DRB Application No.: 07DRB-70236 (P&F) Project # 1006798
Project Name: MERIDIAN BUSINESS PARK II, [REDACTED]
Agent: WILSON AND COMPANY INC Phone No: 348-4024

Project# 1006798
07DRB-70234 BULK LAND VARIANCE
07DRB-70235 MINOR - TEMP DEFR SWDK CONST
07DRB-70236 MINOR - PRELIMINARY/ FINAL PLAT APPROVAL

WILSON AND COMPANY INC agent(s) for BRUNACINI DEVELOPMENT LTD CO request(s) the above action(s) for all or a portion of Lot(s) 3, Tract(s) S-1, S-2A-2 & S-1A, **ATRISCO BUSINESS PARK, UNIT 2** (to be known as **MERIDIAN BUSINESS PARK II, UNIT 2**) zoned IP, located on LOS VOLCANES RD NW BETWEEN UNSER BLVD NW AND AIRPORT RD NW containing approximately 95.9287 acre(s). (J-9, J-10 & K-10)

**PLAT OF
TRACTS A THRU D
MERIDIAN BUSINESS PARK II**
WITHIN PROJECTED SECTION 15, T.10N., R2E., N.M.P.M.
TOWN OF ALAMEDA GRANT
BERNALILLO COUNTY, NEW MEXICO
AUGUST 2007

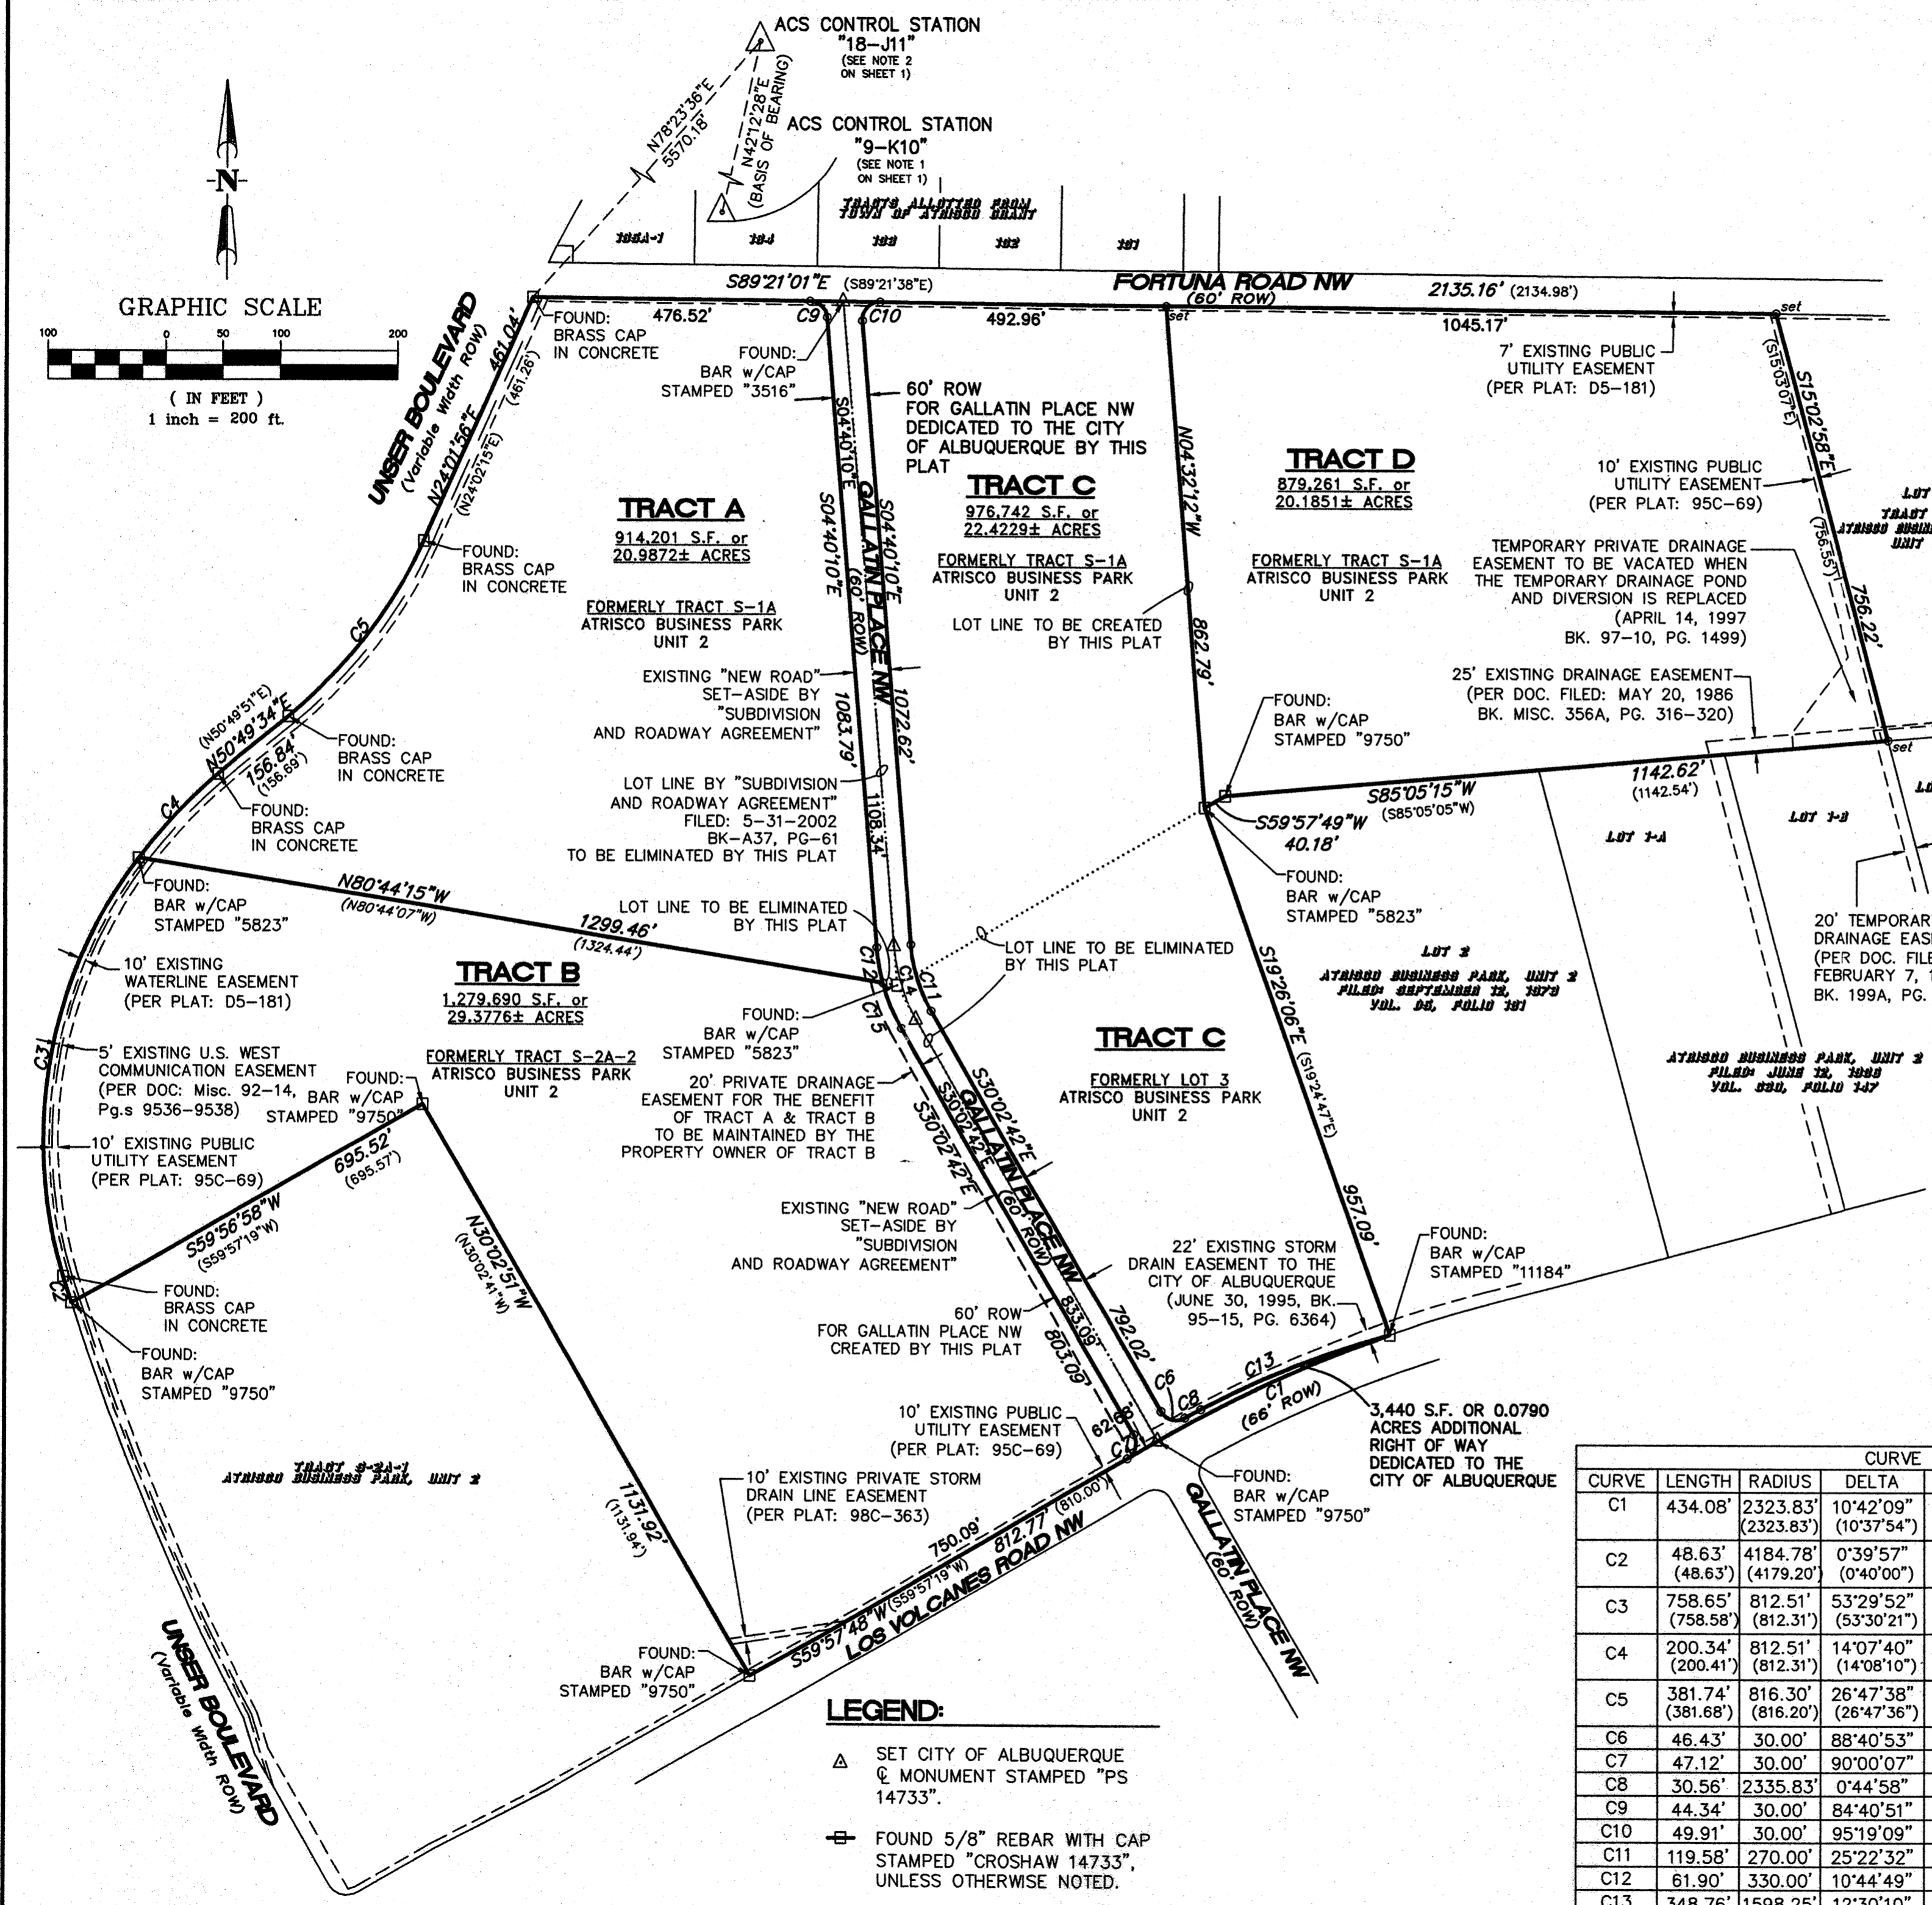
The bulk land plat needs the following: (1) the words, "bulk land" before the word "plat" in the title; (2) the new language from the Subdivision Ordinance banning the prohibition of solar collectors. This language is required on all plats now.
